December 3, 2013

Re: 135 Congress Street

See the attached revised plans indicating the area of the raised roof and expanded interior space. To address your comments see the items in *Italics* below:

PARTIAL SECOND FLOOR PLAN
SCALE 1/4" = 1'-0"

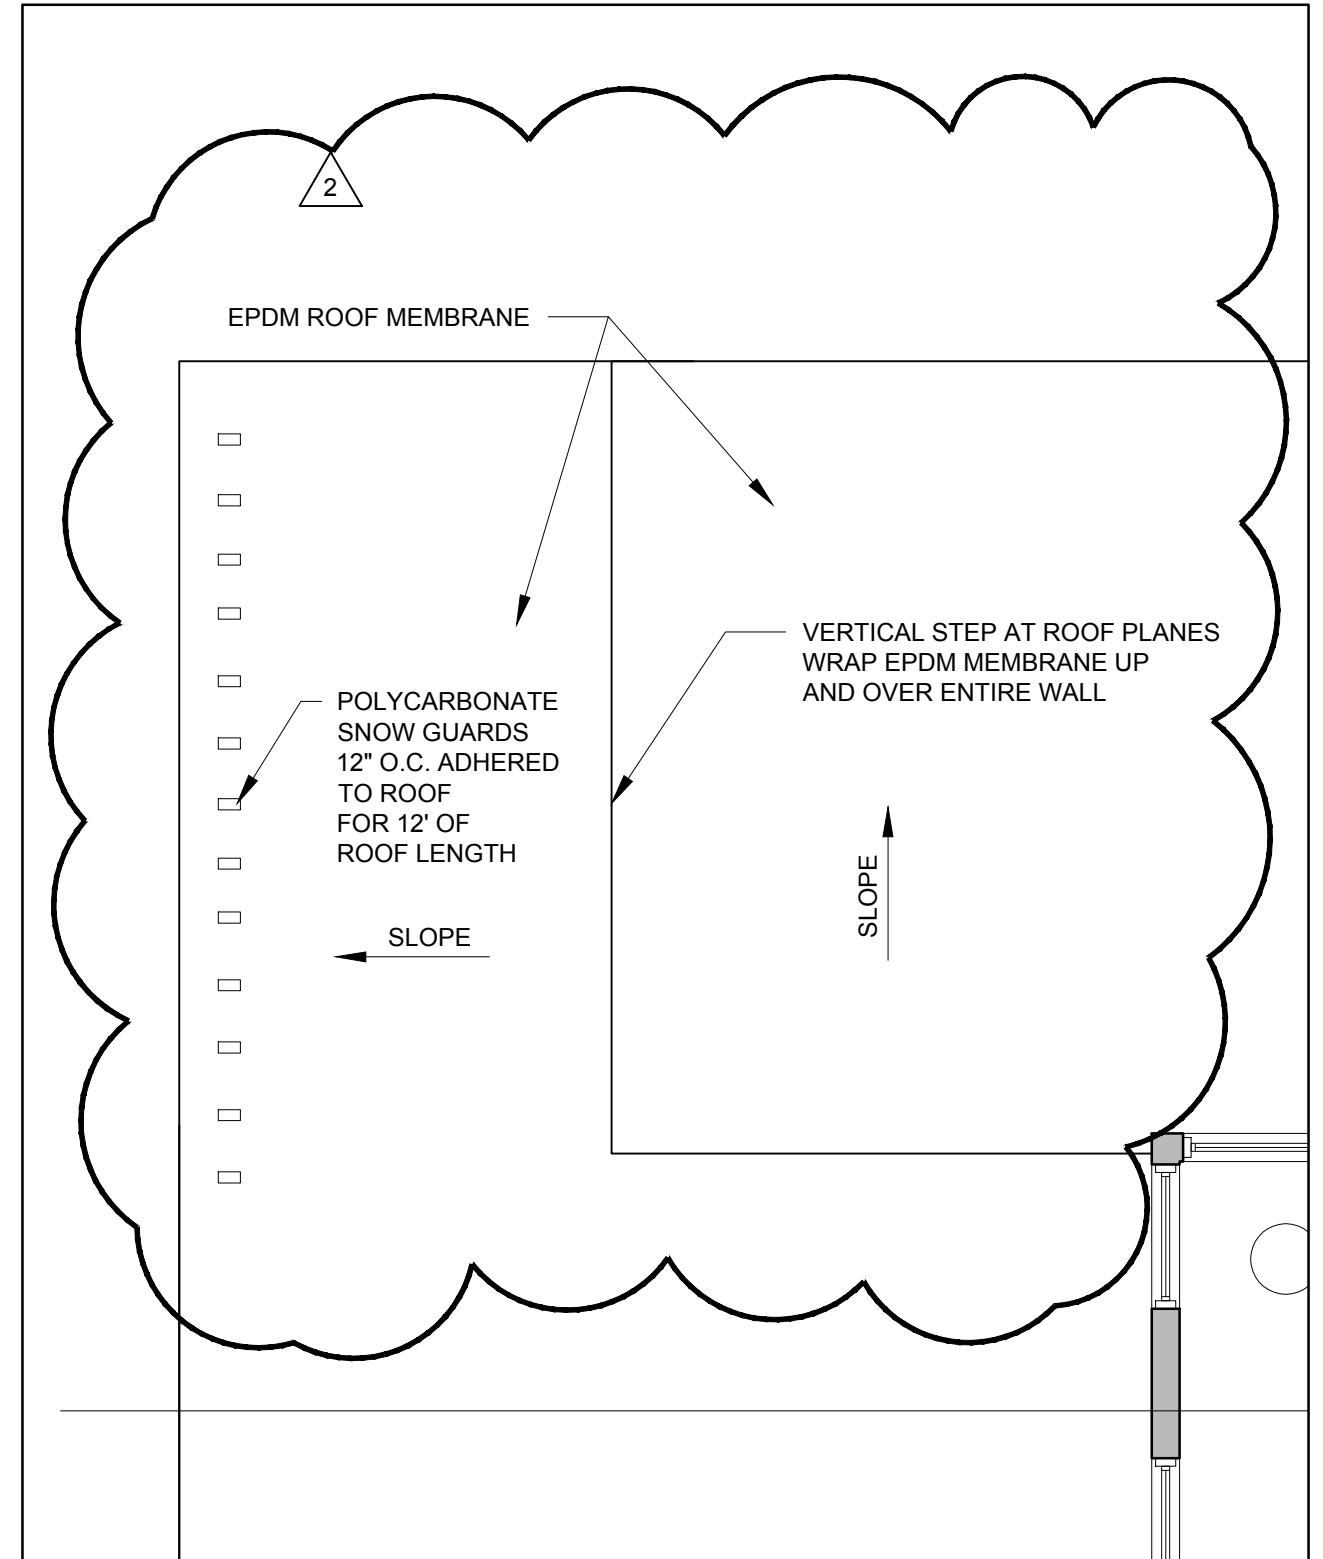
1. Specify that the new exterior wall and is this rated for exposure due to property line distances.

2. Zoning will want to see any increase in habitable space that was previously less than 5' headroom or not currently habitable.

The exterior wall adjacent the existing neighboring building will be 1 hr fire rated

The area that was previously less than a 5' ceiling height that will be part of the raised roof area is 80 square feet.
